Application for non-material amendment following a grant of planning permission.

REQUEST FOR INCREASE OF WIDTH OF PROPOSED EXTENSION

2043 23 100, 110, 200, 210

2043 23 100A, 110A, 200A, 210A

DRAWING TITLE: ELEVATIONS AS PROPOSED

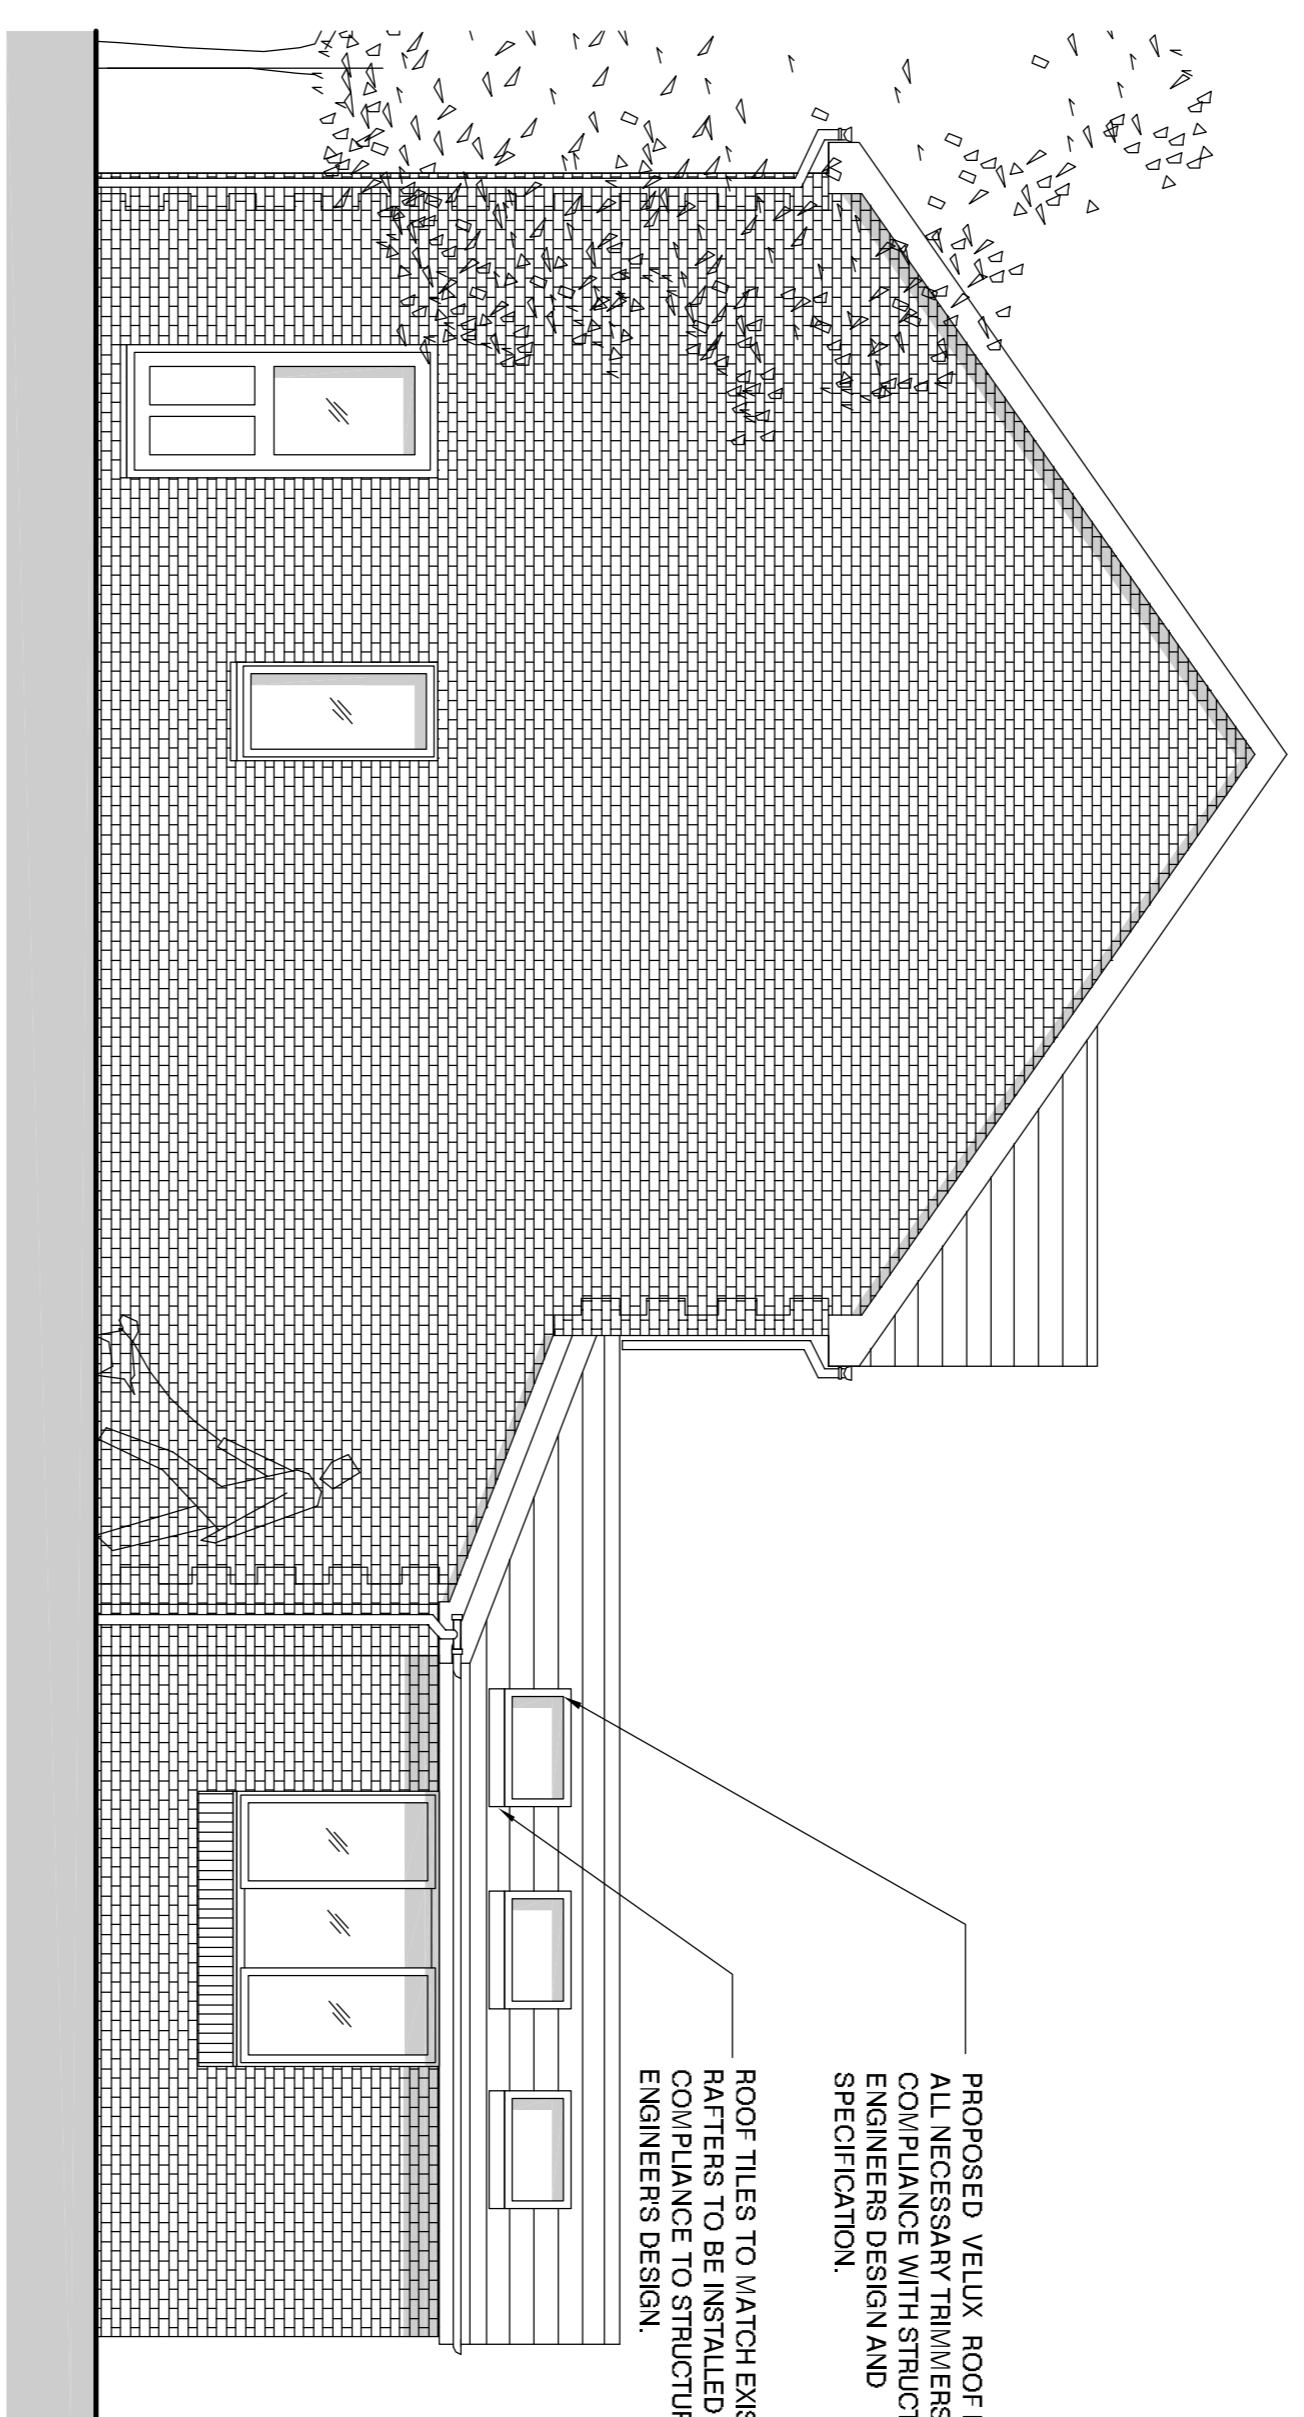
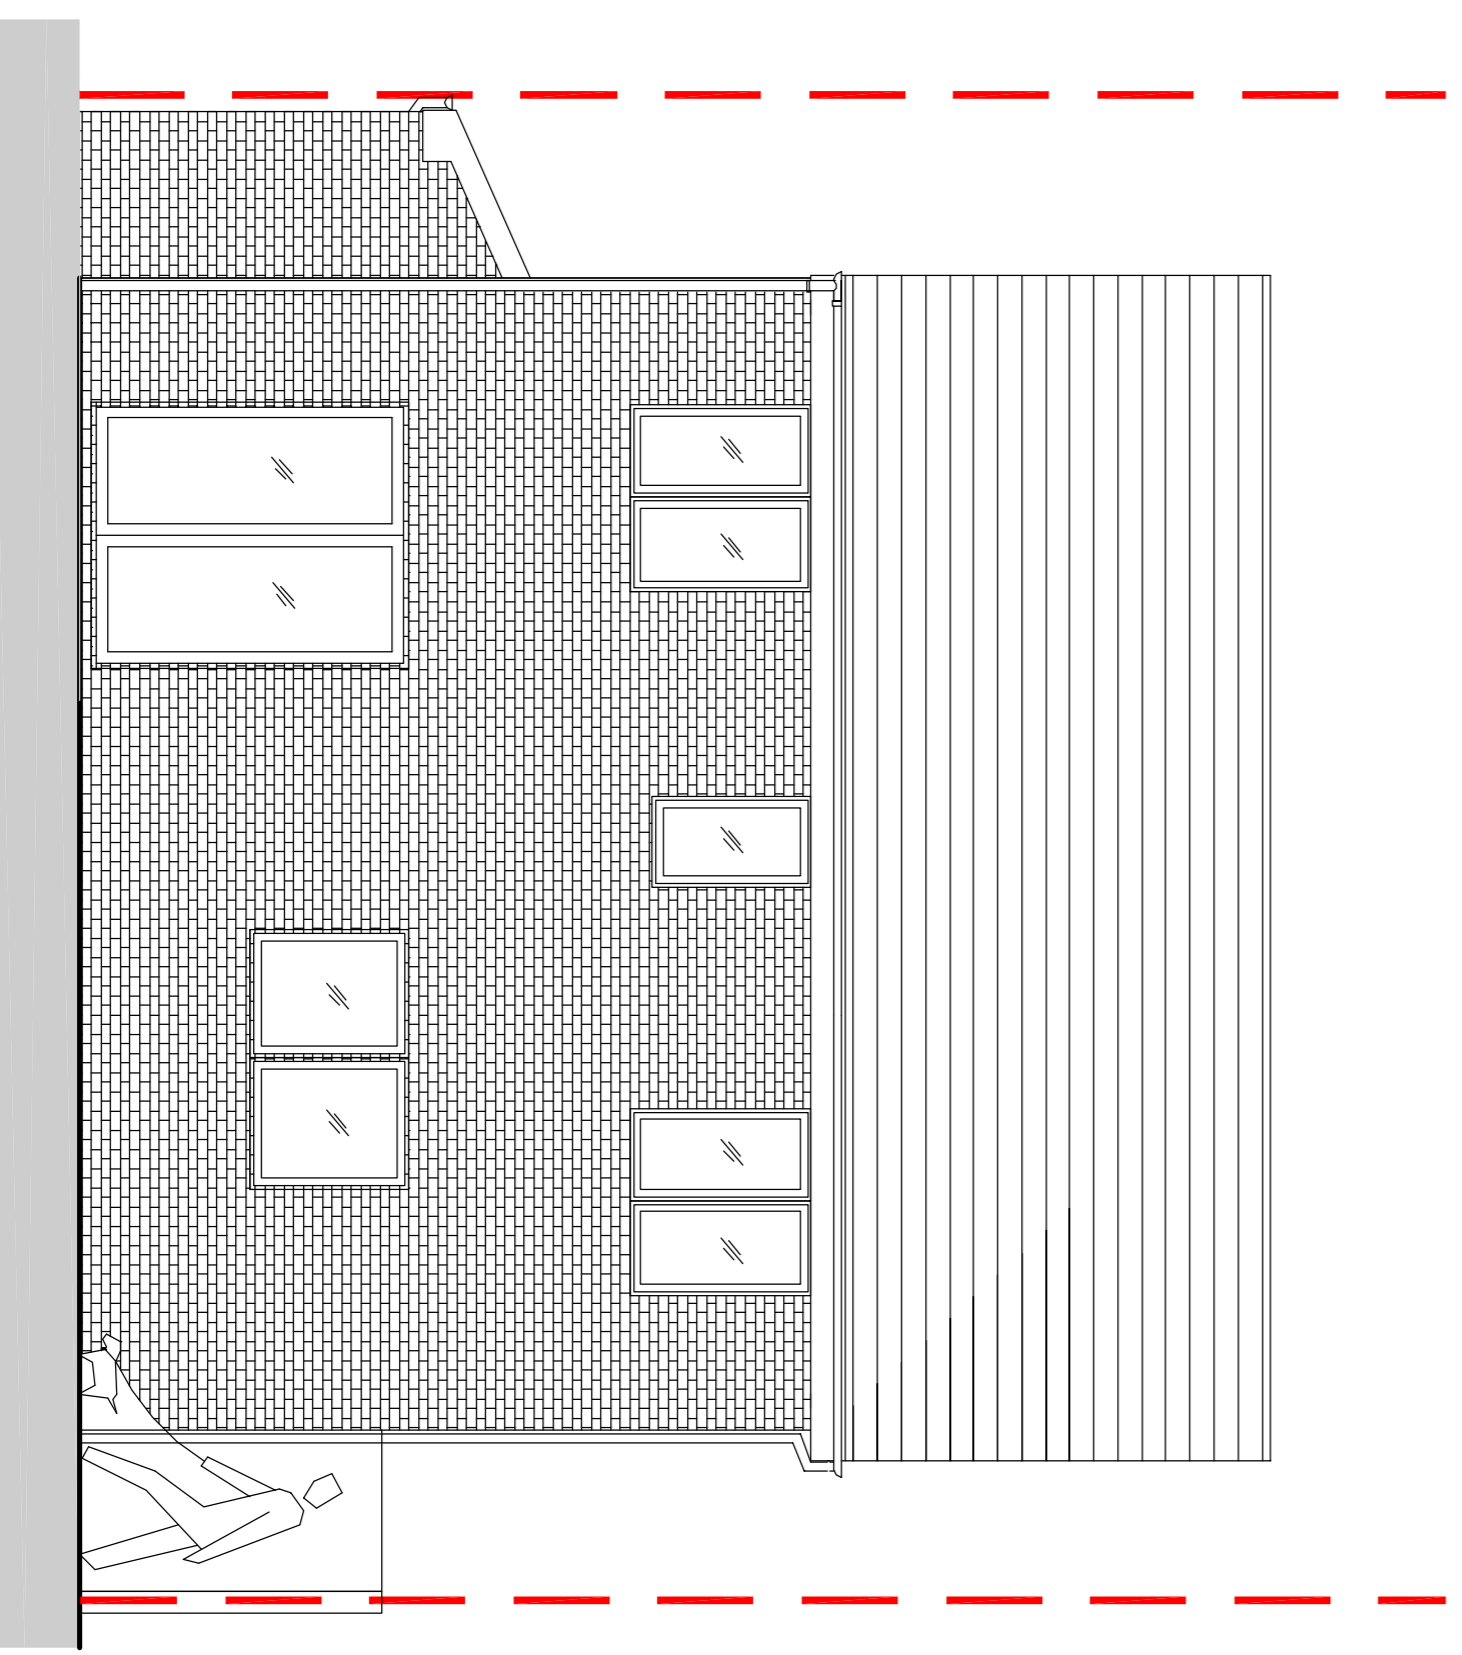
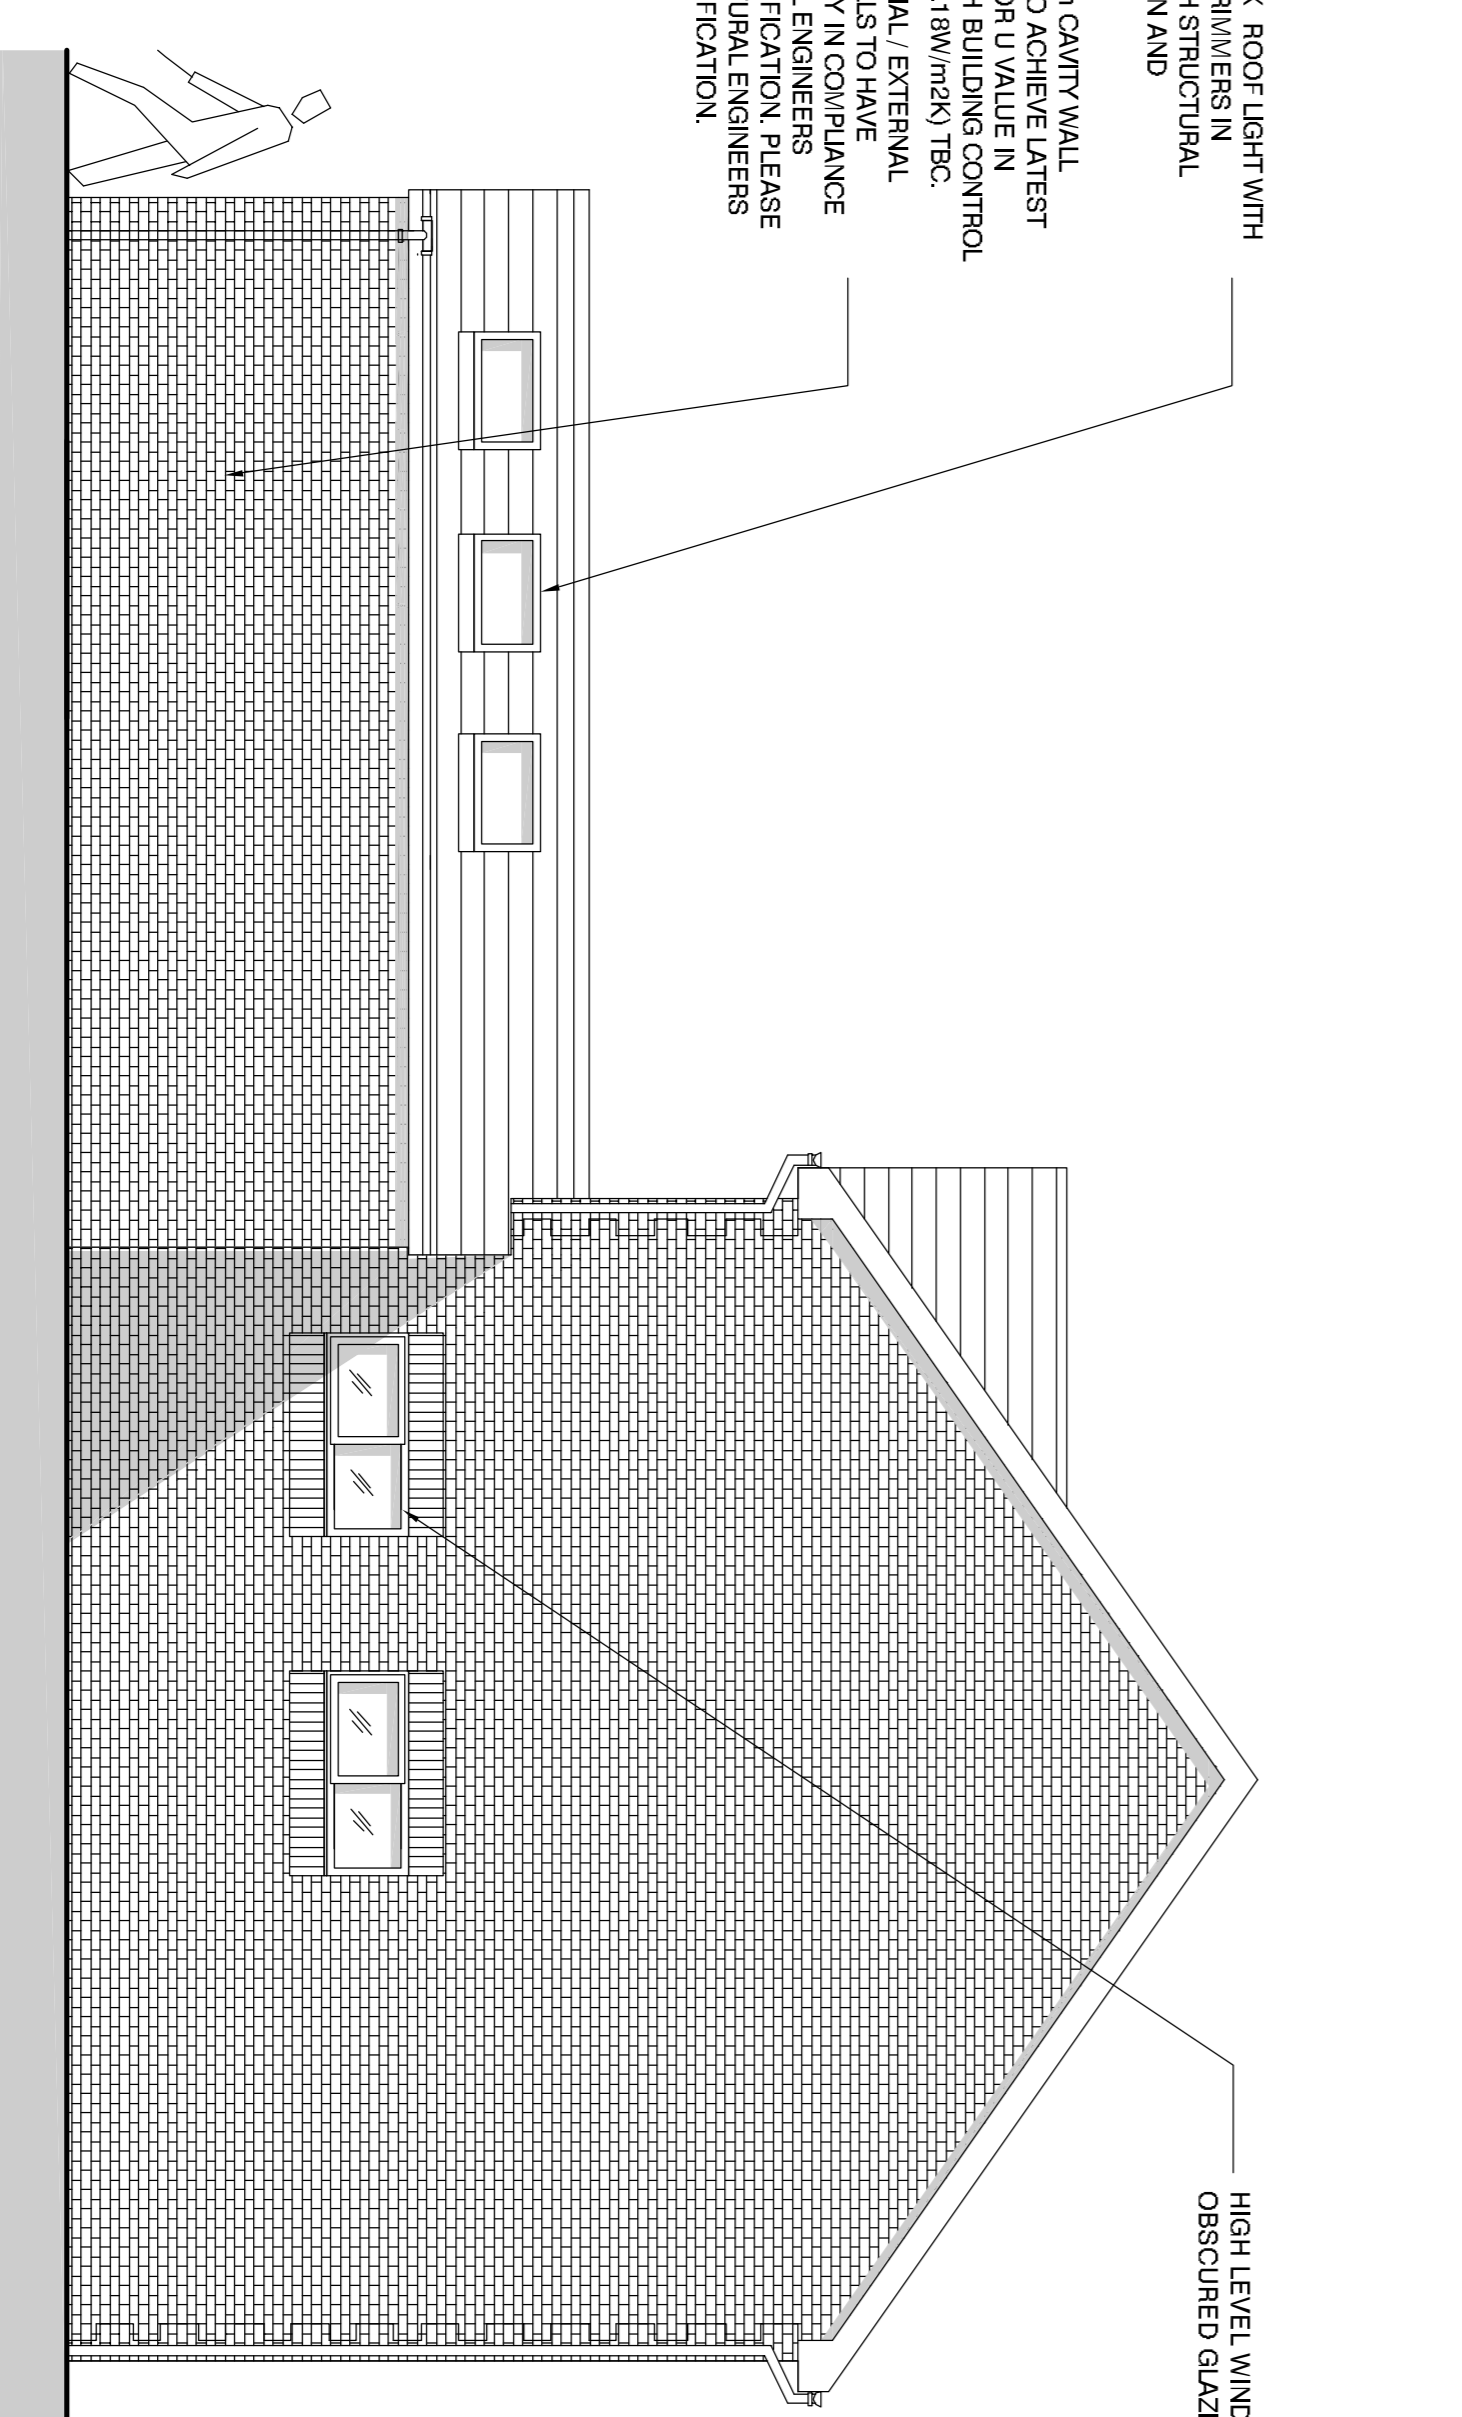
THE CLIENT HAS REQUESTED TO INCREASE THE EXTENSION WIDTH TO THE BOUNDARY.
